DATE: 2/June/99 ADDRESS: 940 Congress ST. CBL: 065-GF003
 REASON FOR PERMIT: To Construct deck on grade (P.T. Wood)
 BUILDING OWNER: Anthony Regios
 PERMIT APPLICANT: _____ /Contractor Dan Baucher
 USE GROUP A-3 BOCA 1996 CONSTRUCTION TYPE 5B

RE: 940 Congress St., Portland, ME., CBL 065-G-003

PROPOSED PIZZA VILLA OUTDOOR DECK

PROPOSED PIZZA VILLA OUTDOOR DECK

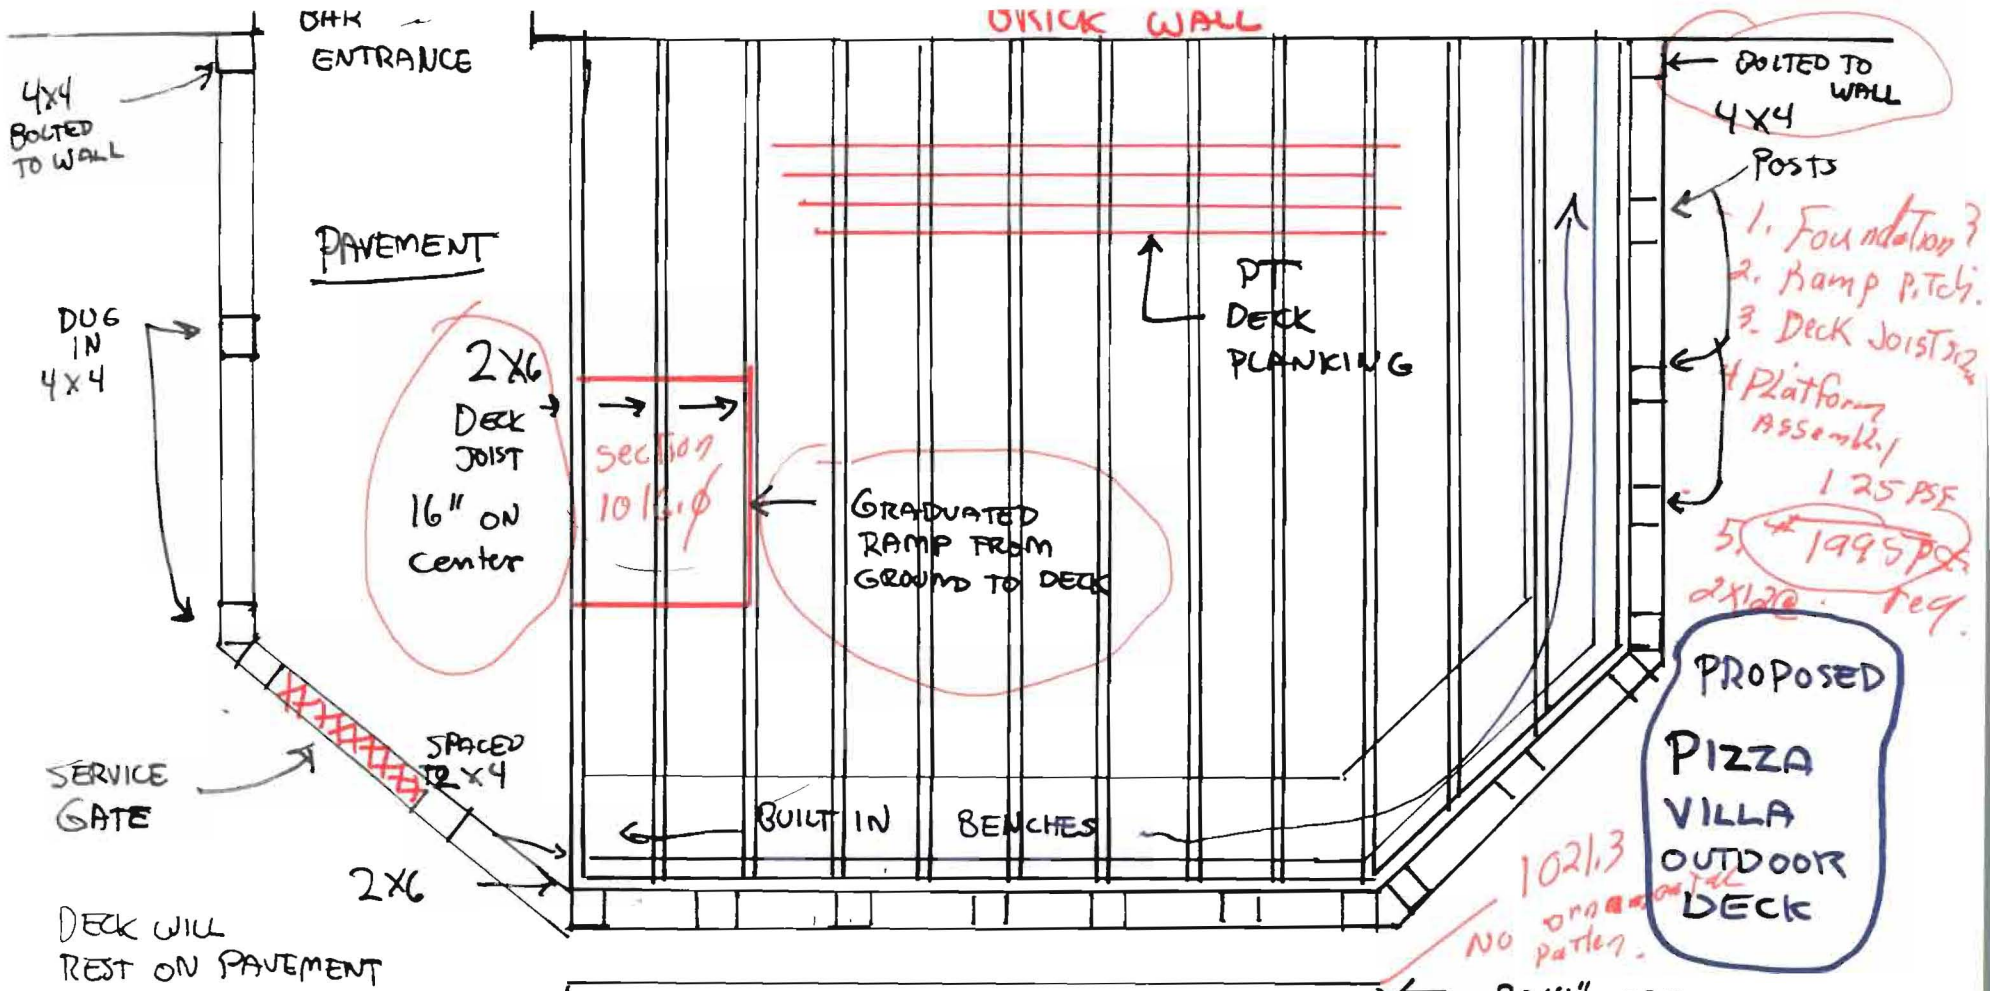
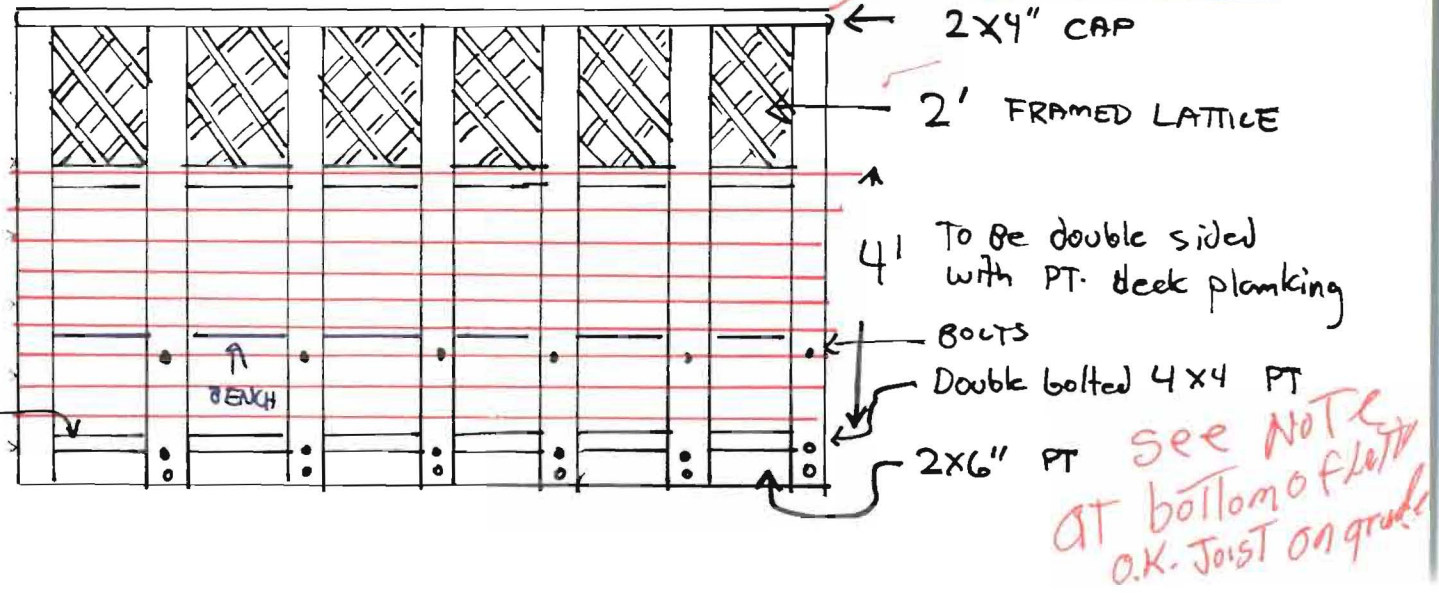
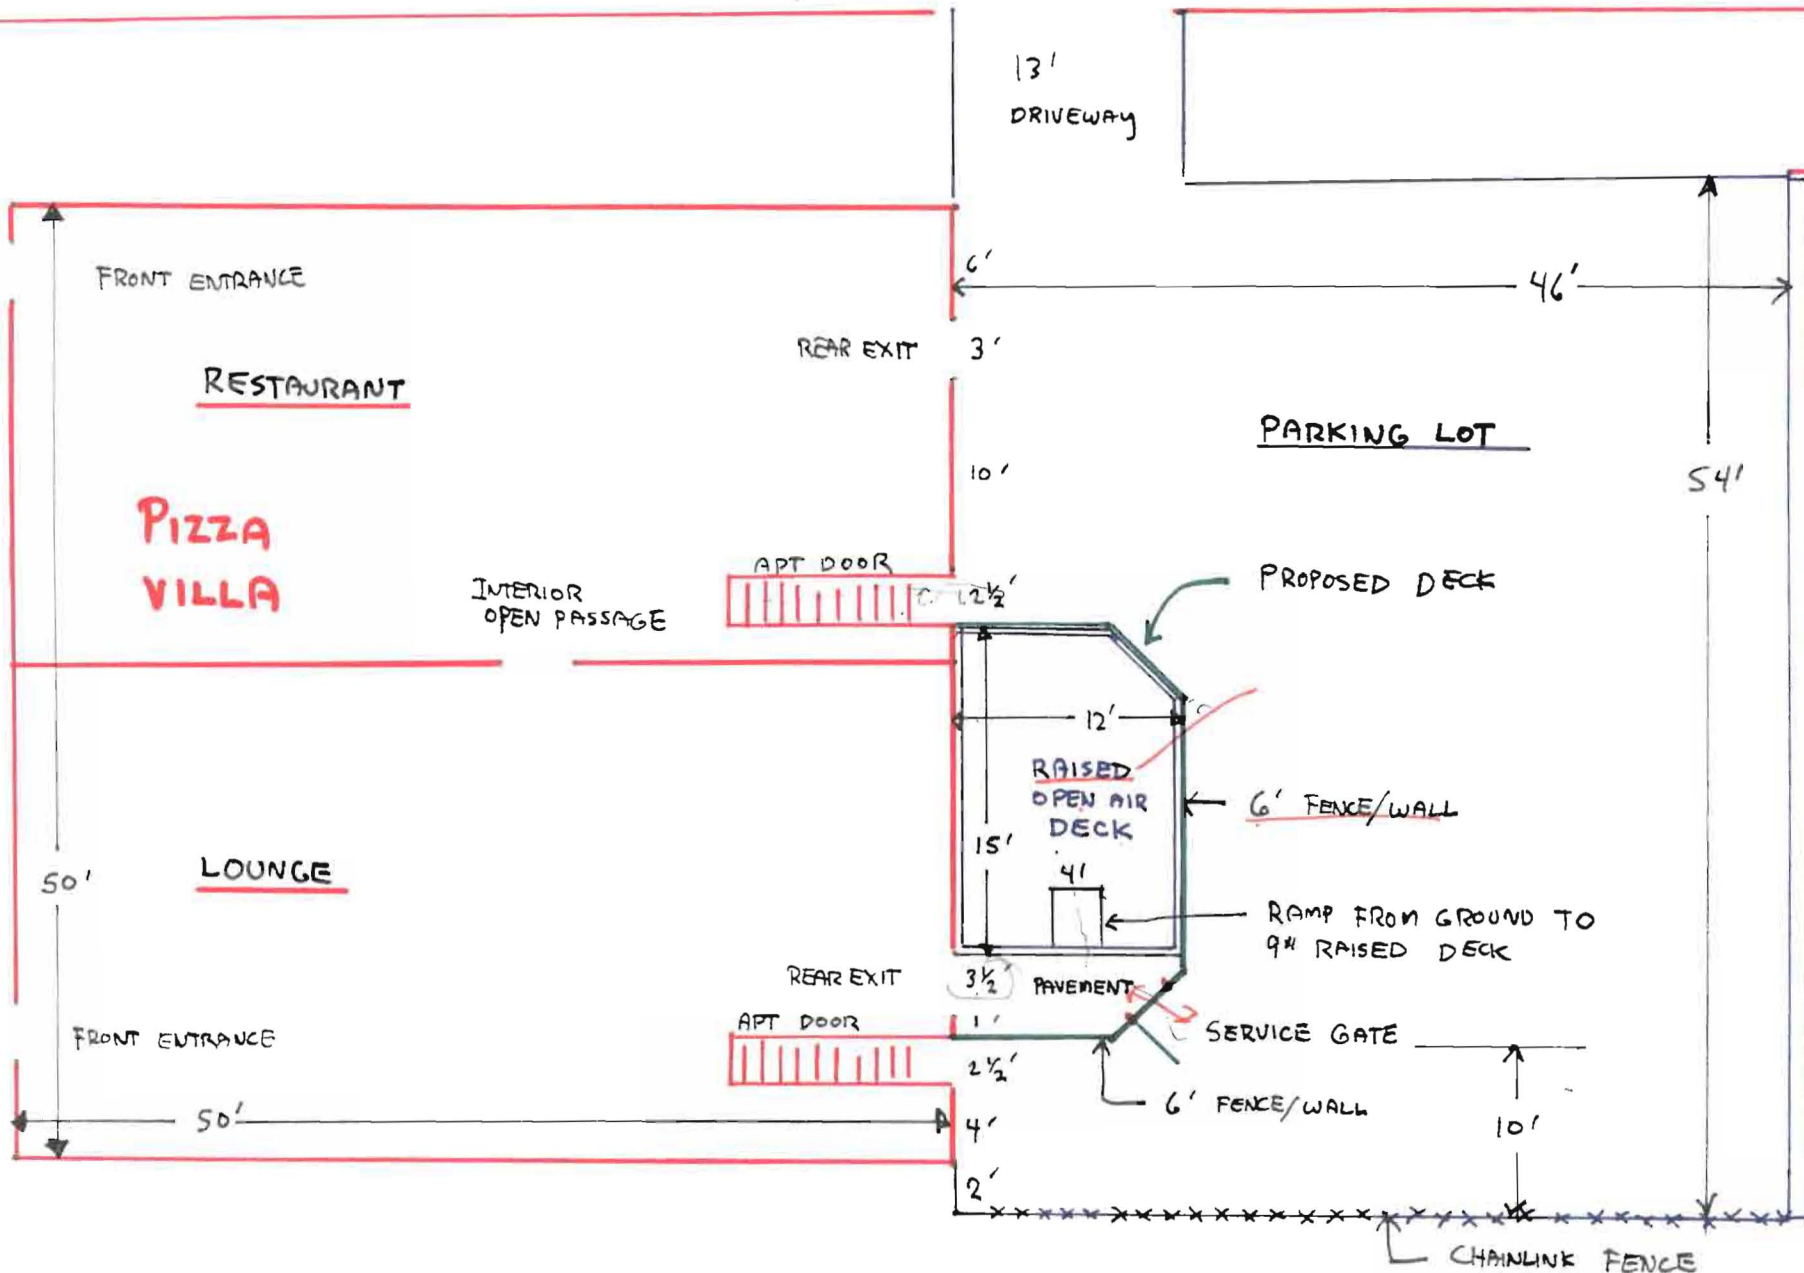
1. The proposed floor joists are 2"x6" spanning 12'. The minimum requirement for a span of 12' carrying a 125 PSF live load (assembly platform) would be 2"x12" at 12" O.C.
2. Your application did not show any type of foundation - 10" piers on footings 4' below grade with anchors between footing, piers and framing would be a minimum requirement.
3. The proposed ramp does not have any details - Section 1016.0 of the building code has these requirements.
4. The proposed guard around the deck does not meet the requirement of Section 1021.0 of the building code (Section 1021.3 opening limitations).

*6/June/99 Talked with owner and contractor
The 2x6" Joist will be resting the entire length on
The ground - No opening between grade on joists.
All material to be P.T. Wood*

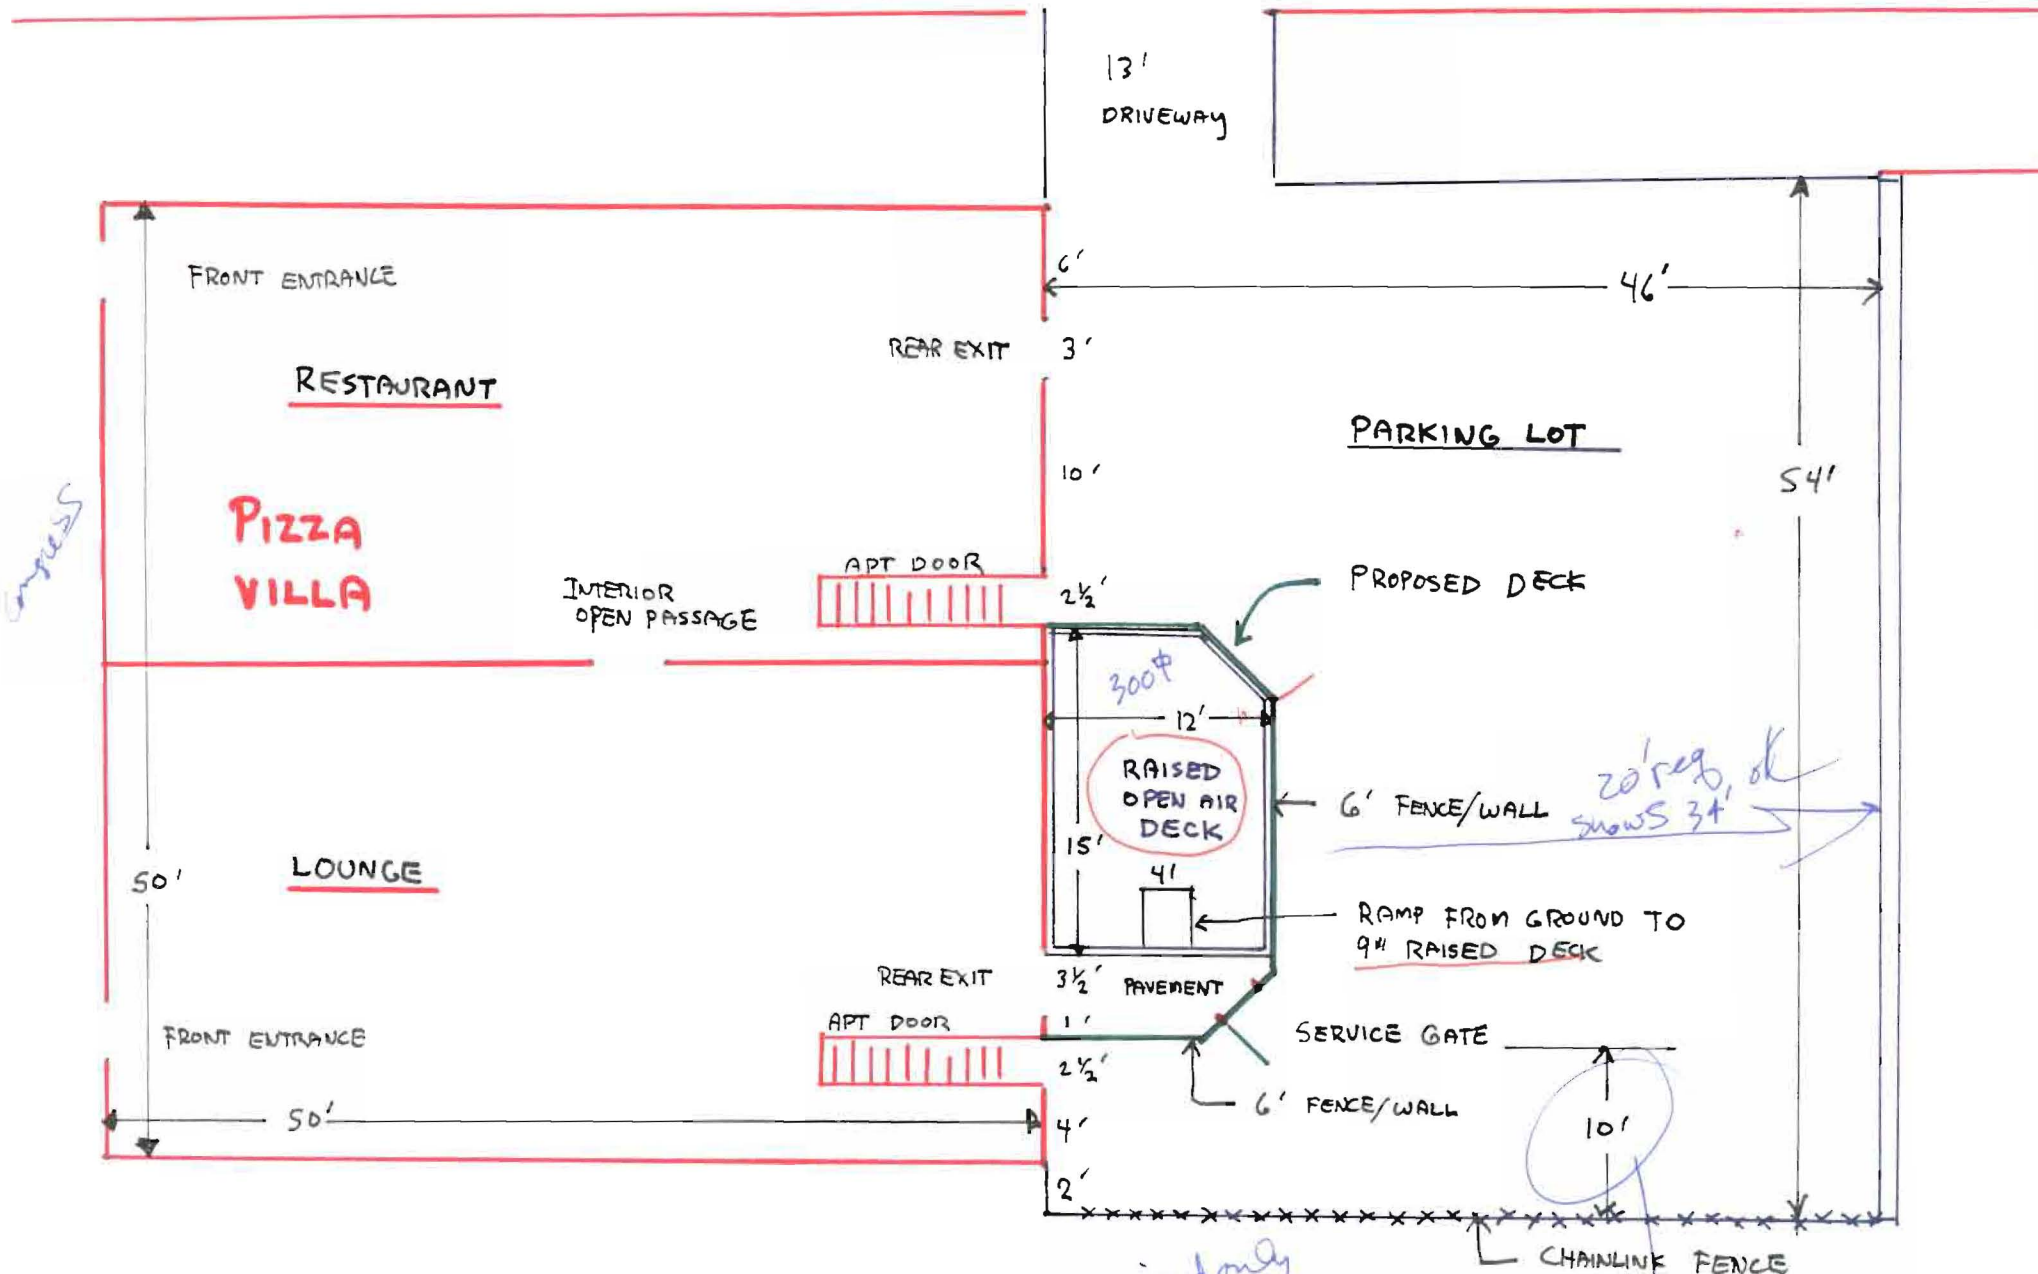
20' from rear required only
